Department of Primary Industries

OUT14/40922

**SIMTA Moorebank Intermodal Terminal (SSD_5056 and EPBC 2011/6086)
Response to exhibition of Environmental Impact Statement**

SIMTA Moorebank Intermodal Terminal (SSD_5056 and EPBC 2011/6086) Response to exhibition of EIS Comments by NSW Office of Water

Figure 6.4 Options A1 and A2 – indicative only

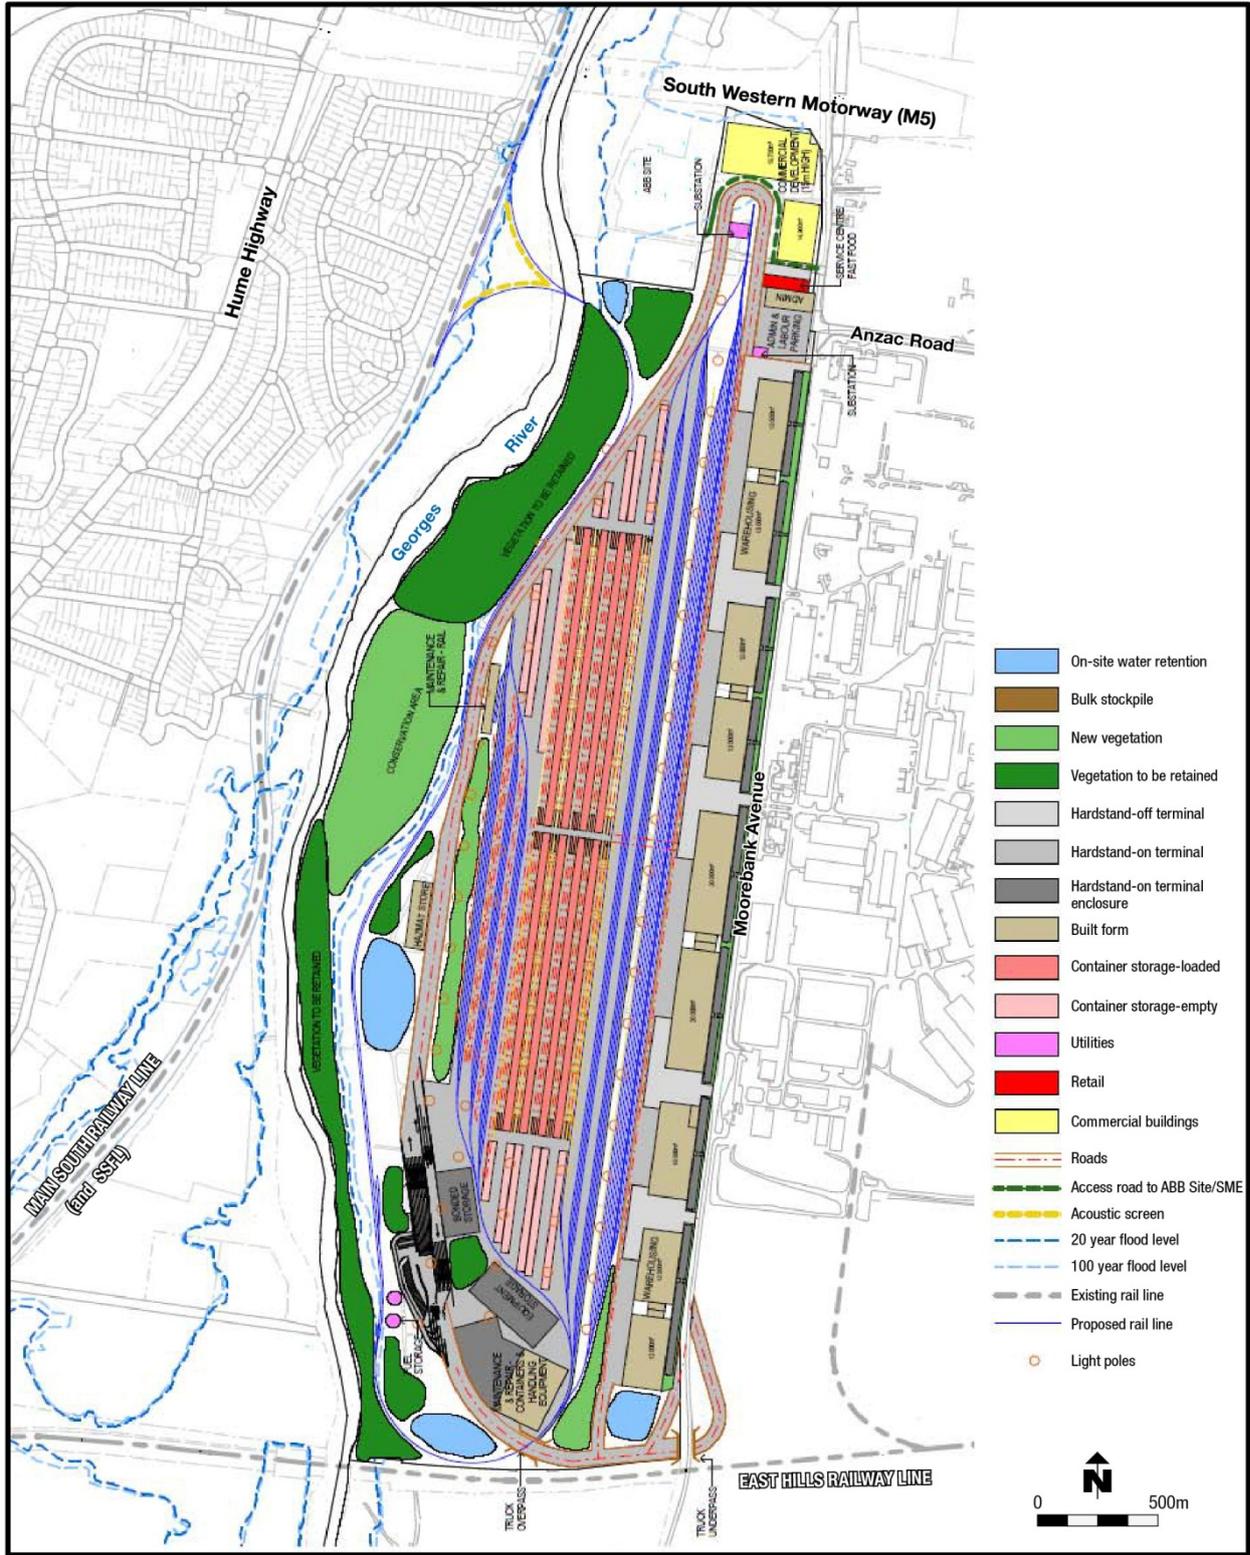
- Figure 6.4 (the preferred technical Options A1/A2 shows the riparian corridor is greater than 250m wide along the northern most section of the Georges River and it indicates existing vegetation in this area is to be retained (page 6-25, Volume 1a).

It is recommended the figures in the EIS are amended so they are consistent in relation to the proposed riparian corridor width. Wider riparian widths along the northern most section of the Georges River are supported particularly as remnant alluvial woodland occurs in this location and Technical Paper 3 indicates riparian land within 50m of the river is considered of high value due to the function of vegetation in this area as a wildlife corridor (page 30).

**Figure 8.4 Indicative IMT layout associated with the northern rail access option (at end of Phase A) - 2018**

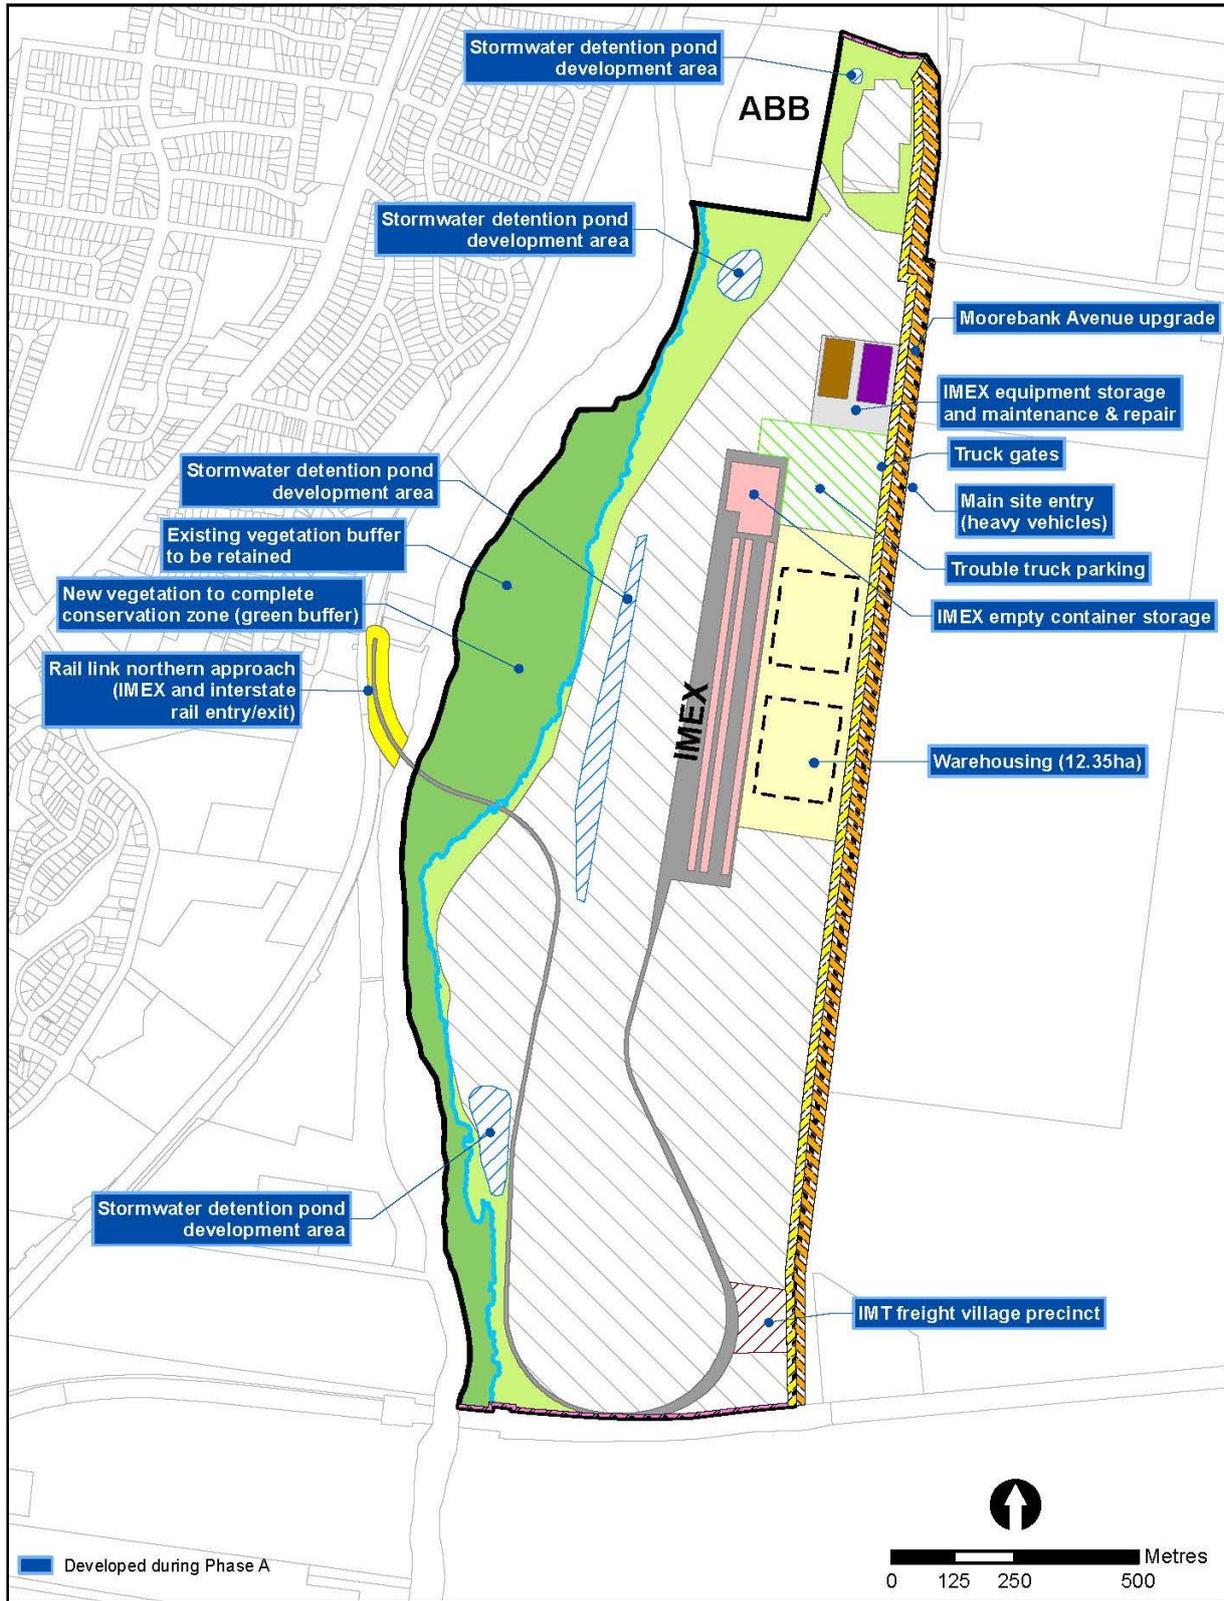
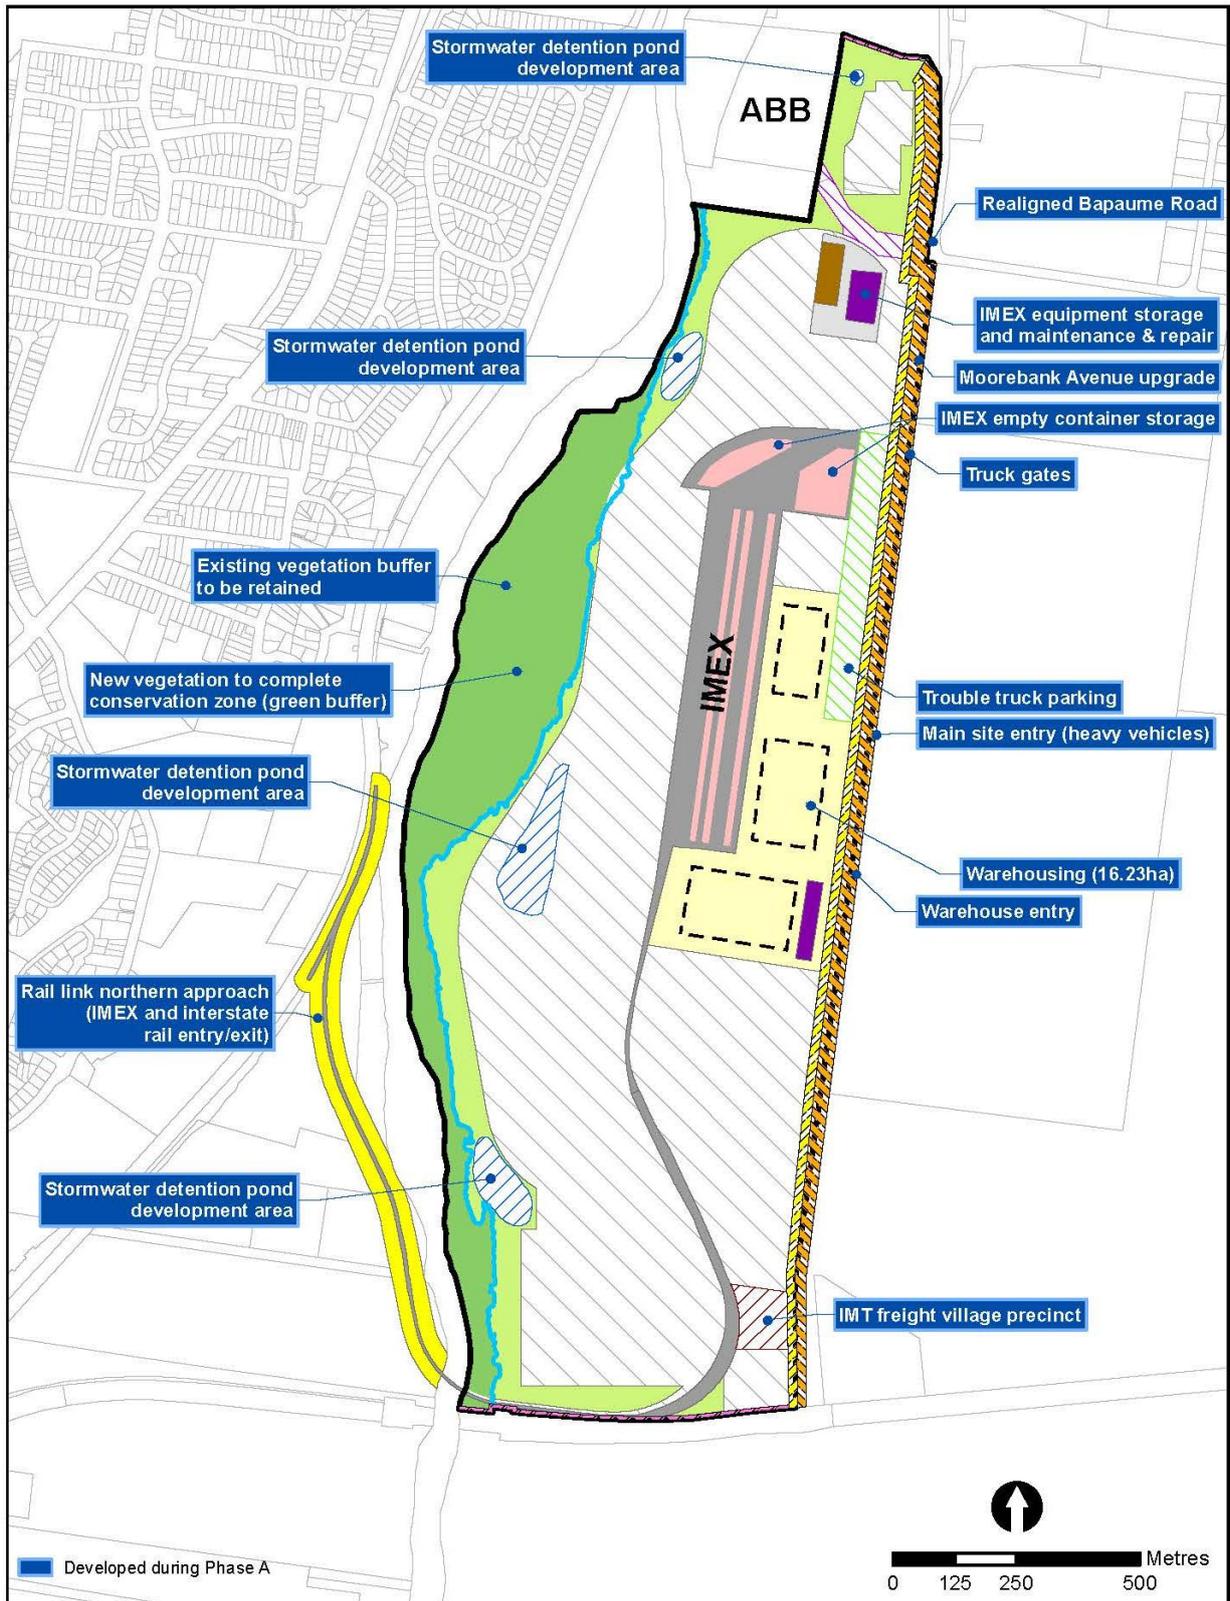
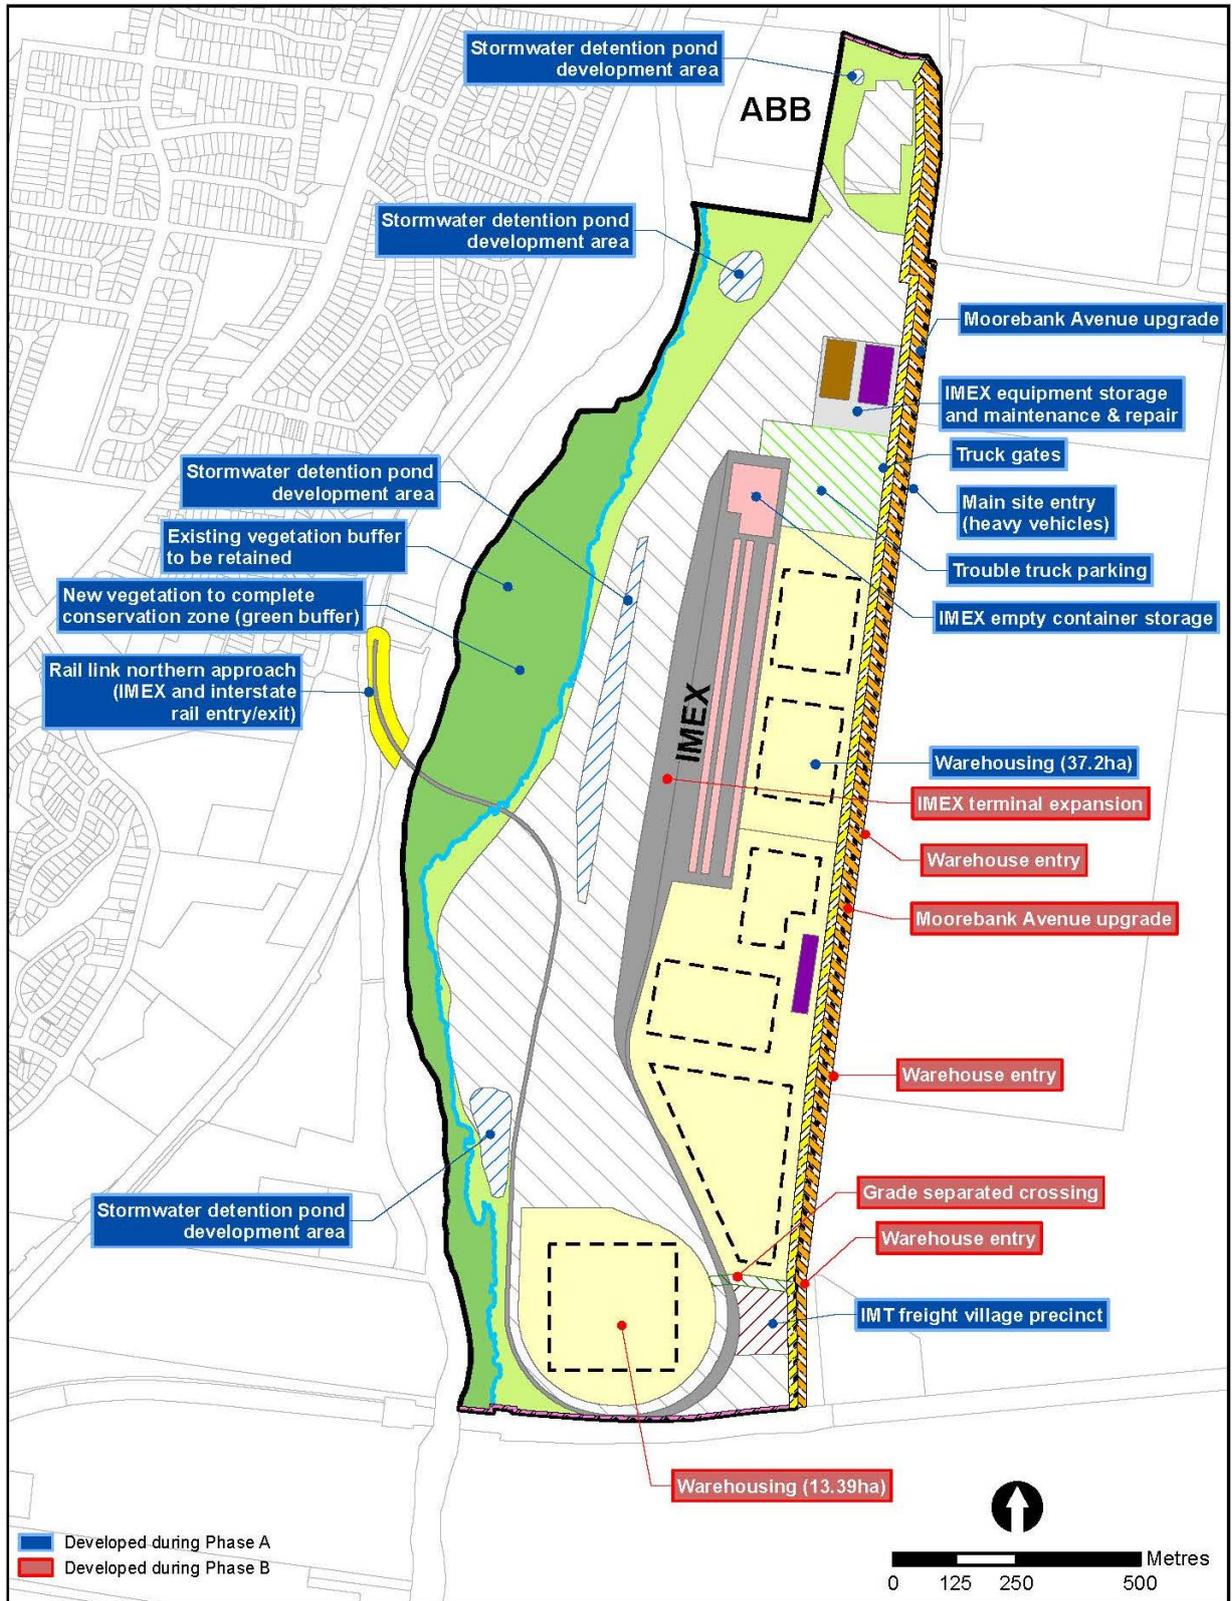
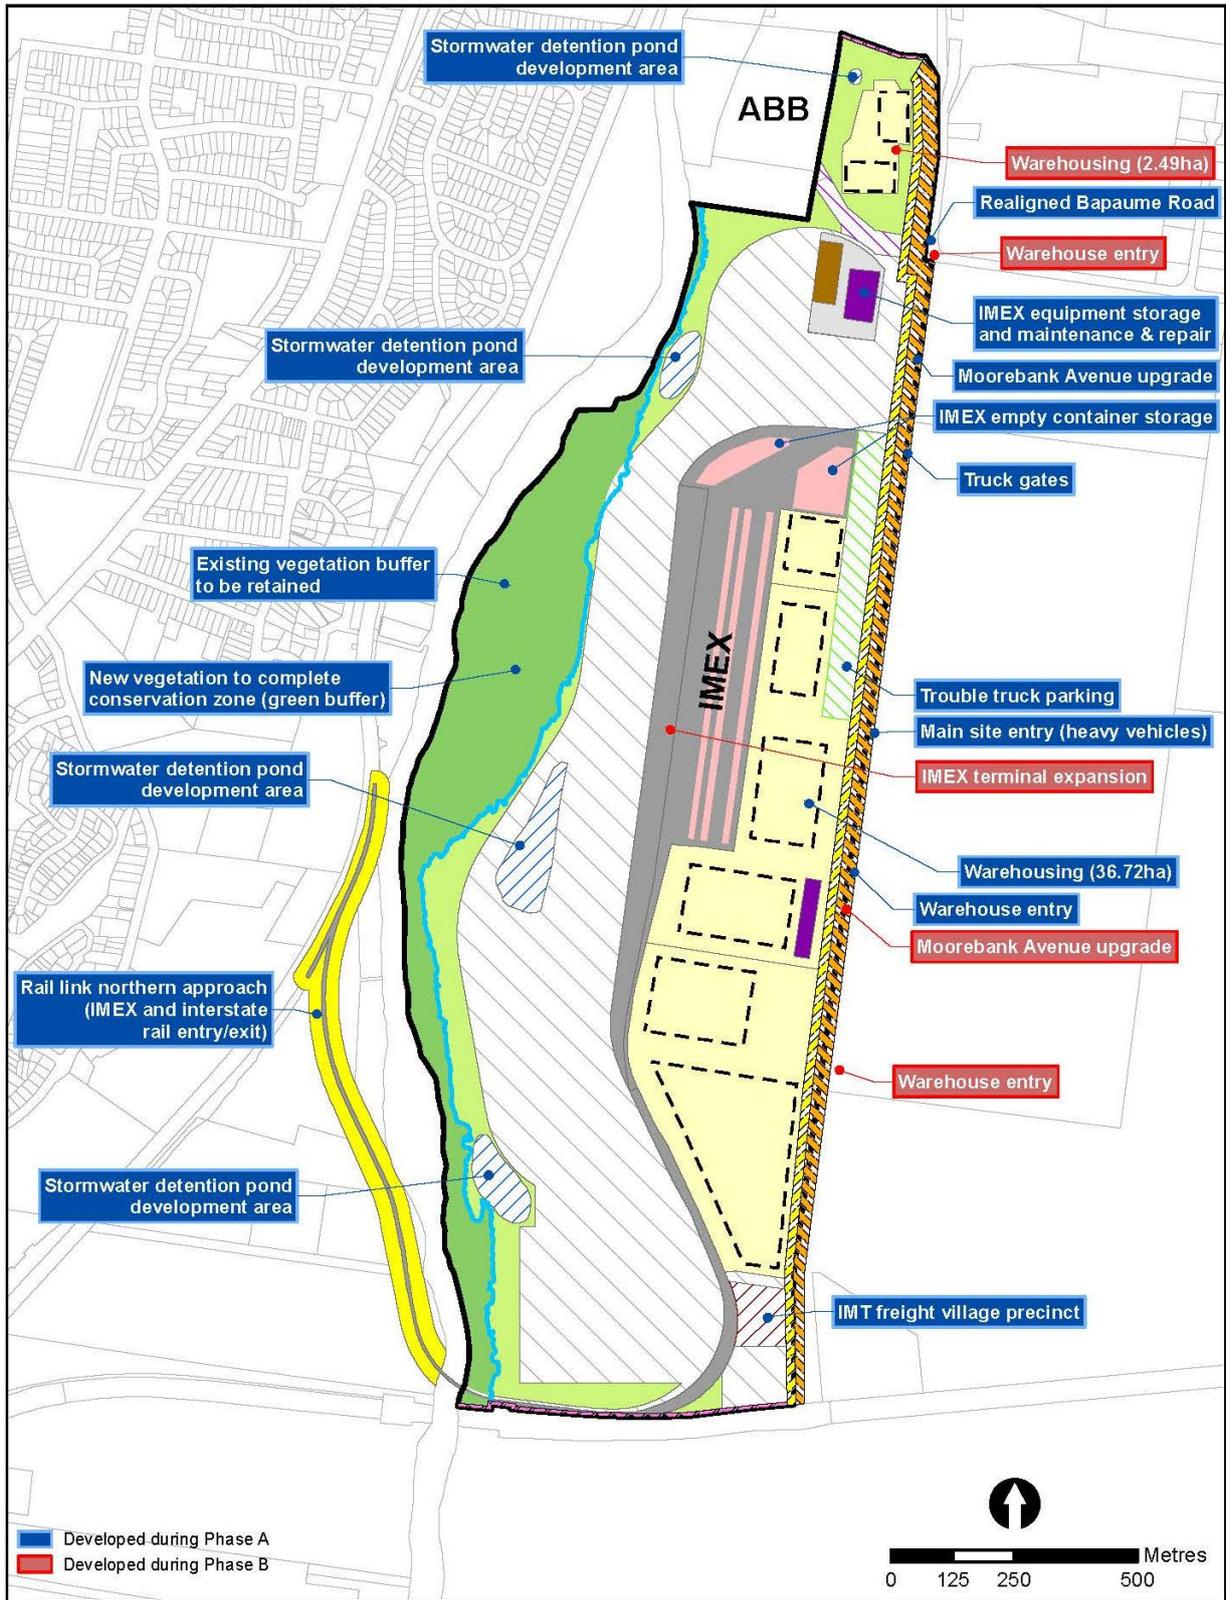
- Figures 8.4 -8.12 show a very narrow riparian corridor along the northern most section of the Georges River. The corridor width on these figures appears to follow the 1% AEP flood level (see Figures 7.2 with Figure 7.3 in Volume 1a).

- Figures 13.5 -13.7 show a wider conservation area is proposed along the northern most section of the Georges River than shown in Figures 8.4-8.12.
- Figures 13.8 - 13.10 show the proposed biodiversity offset areas are wider along the northern most section of the Georges River than the conservation areas shown in Figures 8.4-8.12.
